Application No: M/83/21/HH
Site Address: 42 Sea Way Middleton on Sea PO22 7SA
Description of works: Single storey rear extension and first floor side extension

Thank you for your internet representation made on 2nd August 2021 which has been recorded as no objection with the comments as follows:

sheet 2 of 4

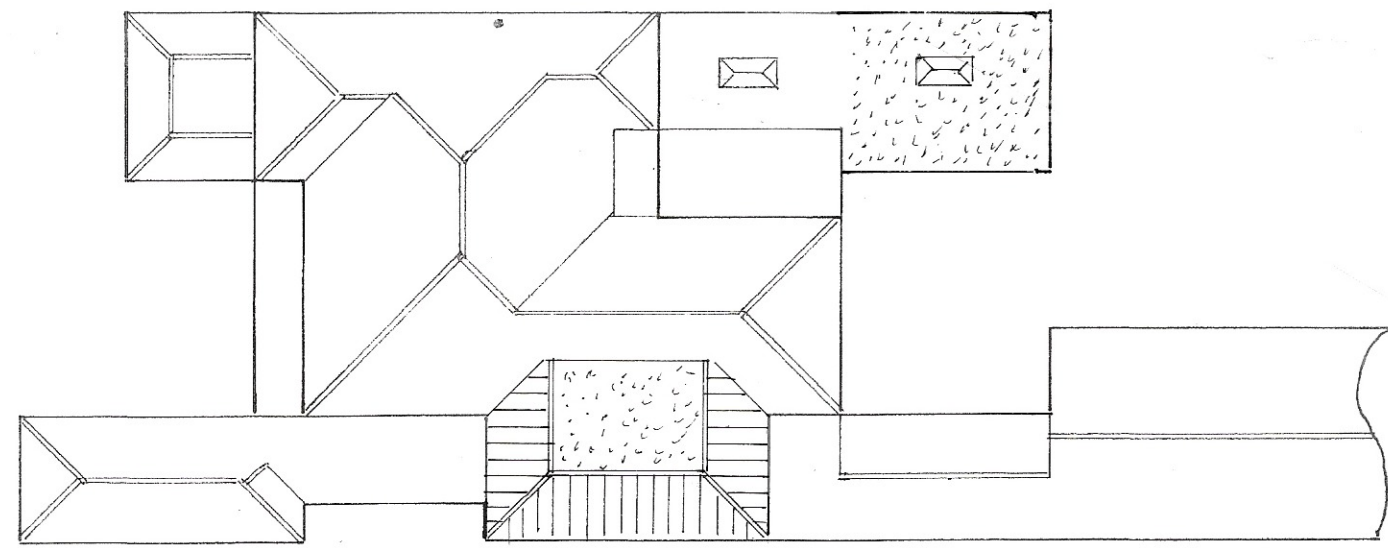
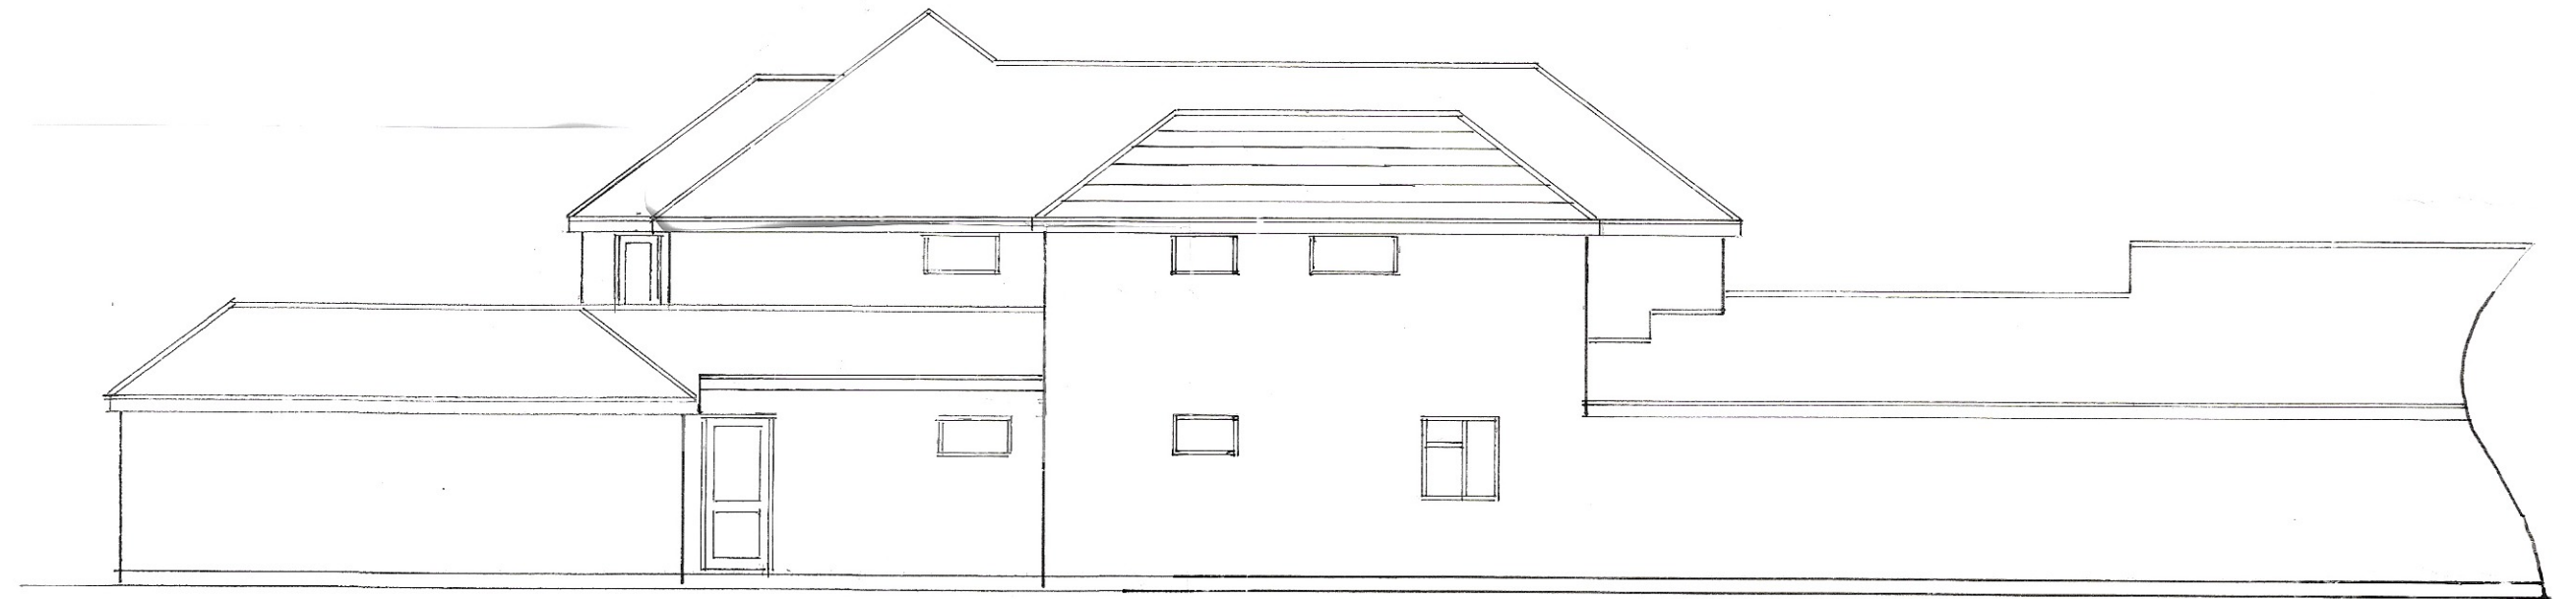
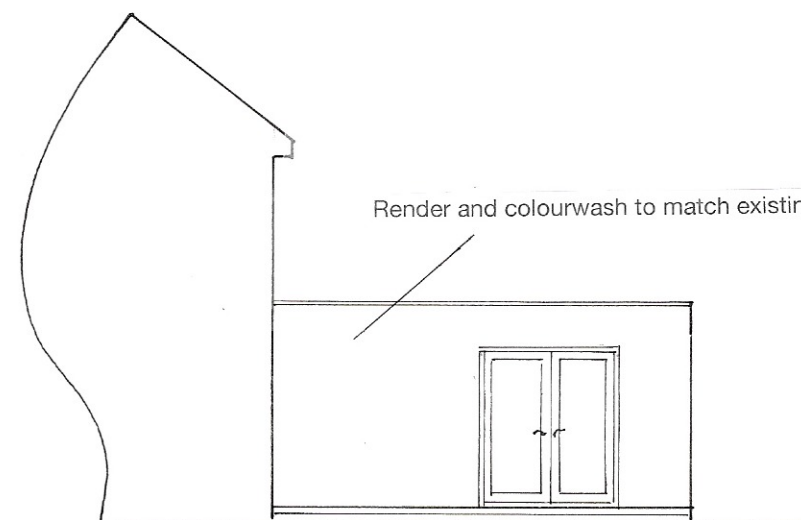
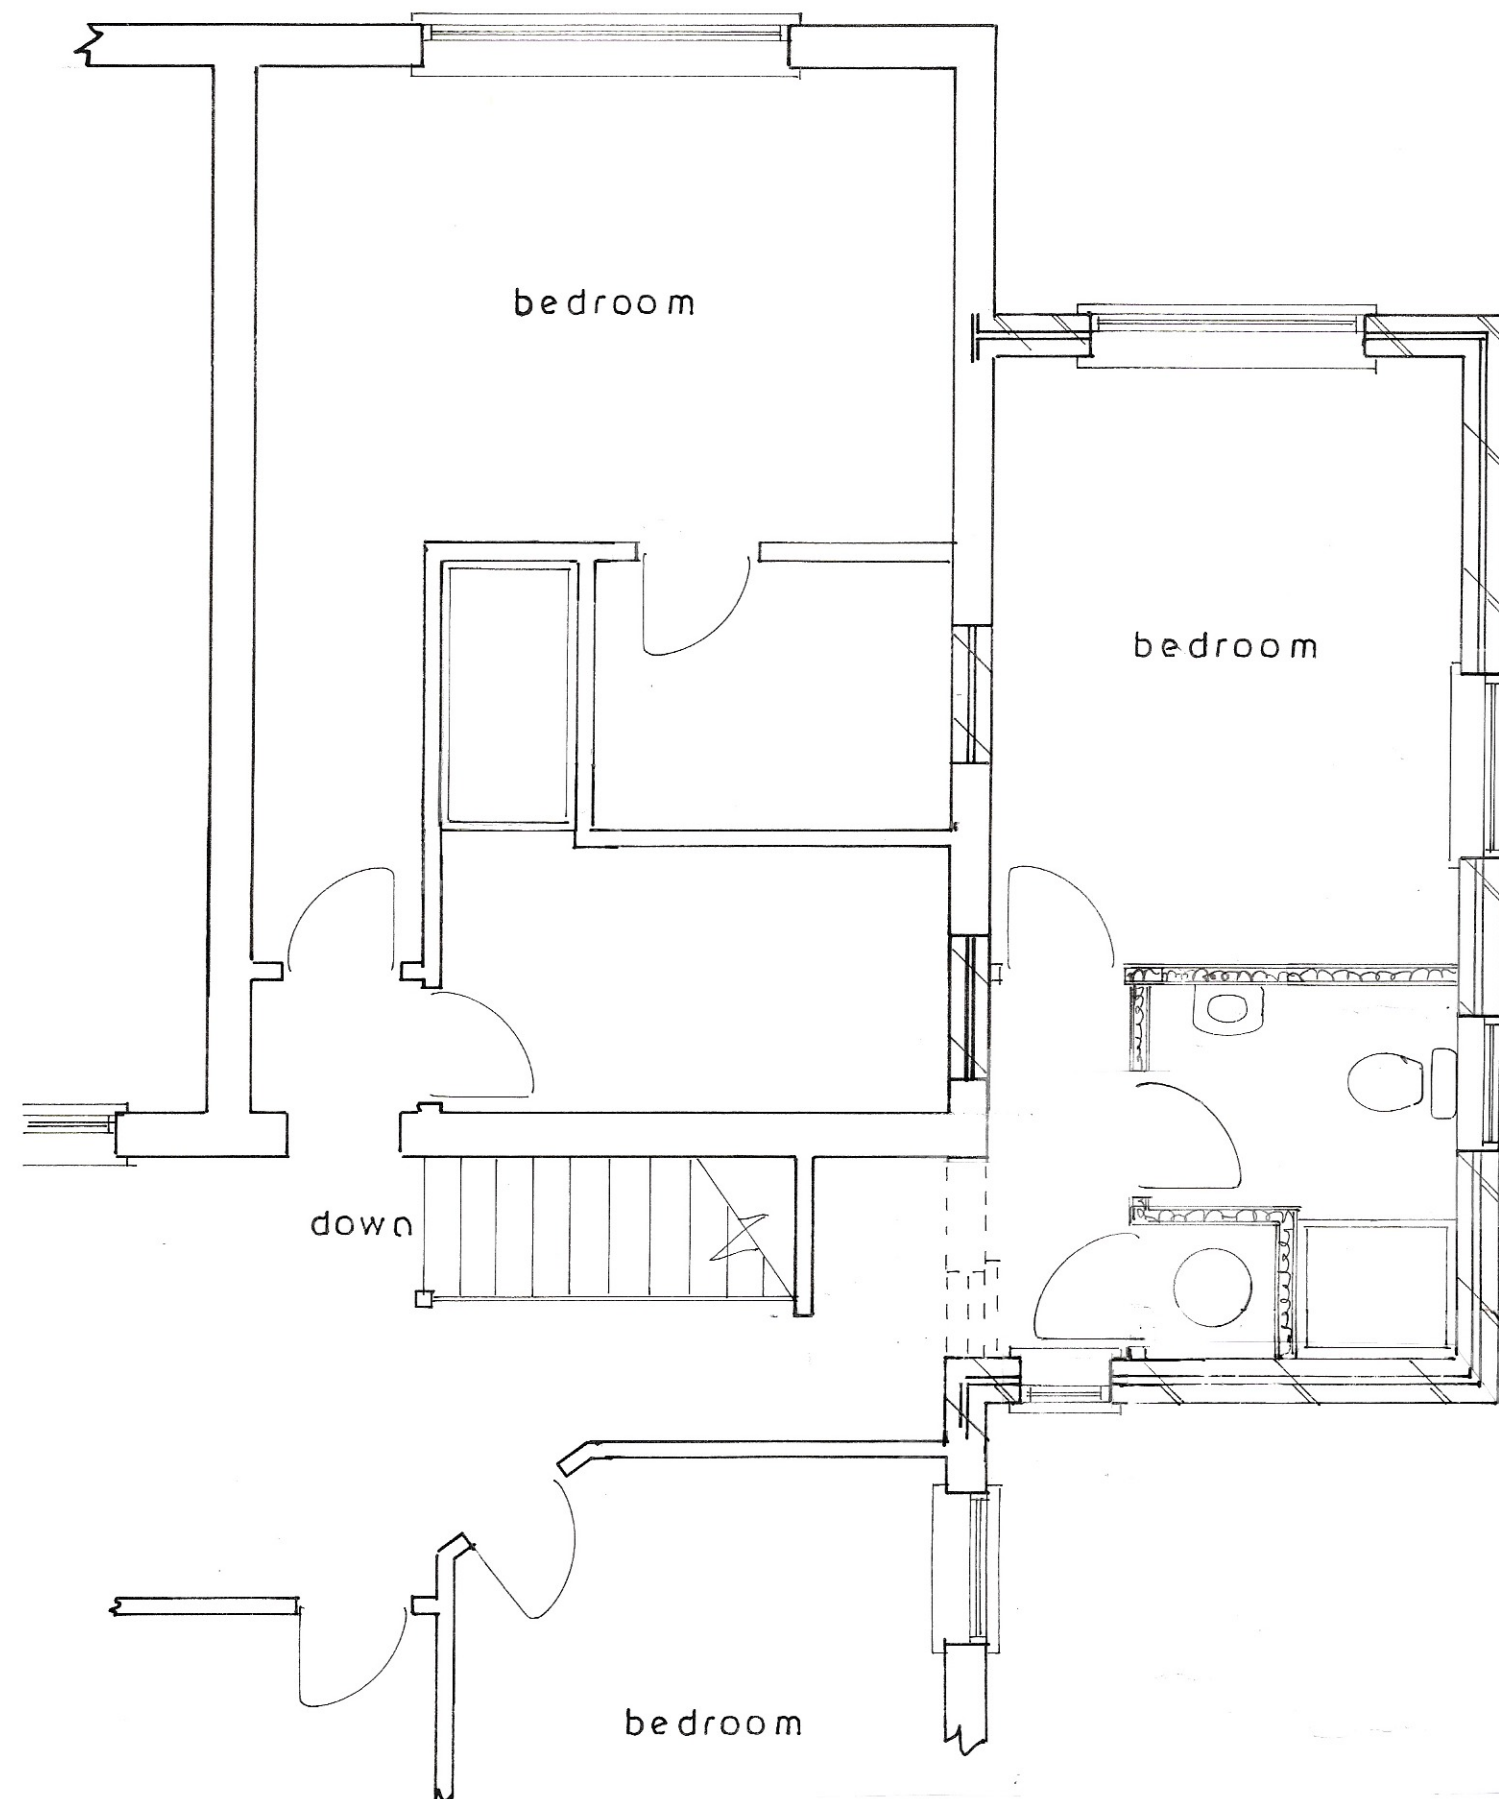
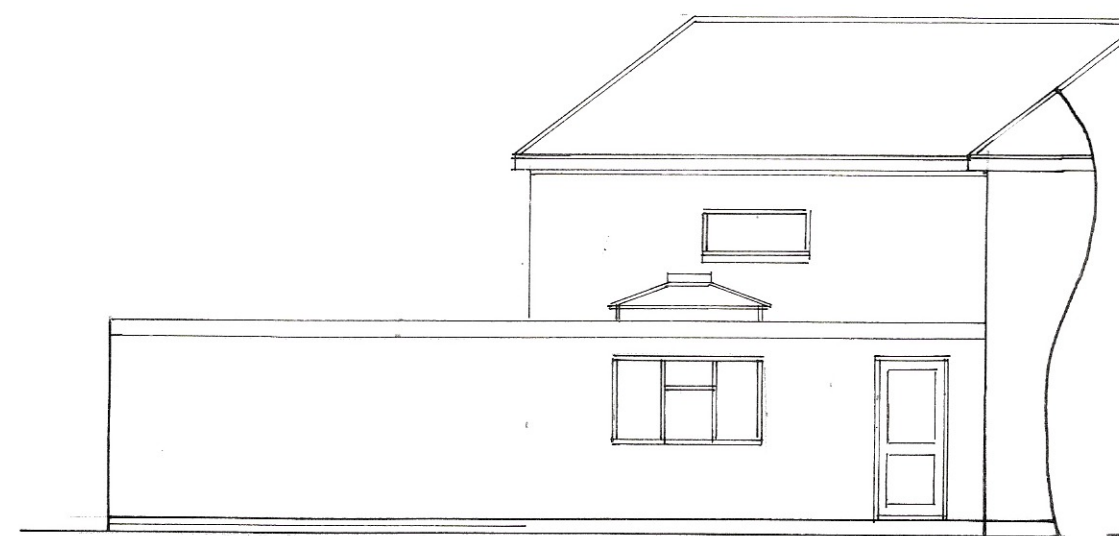
I have a concern about the windows on the East side extension of number 42. I have 2 bedroom windows on the West of my house and one of them faces where the new planned extension will be.

I would like it if the planned windows on the East side of the extension were obscured glass.
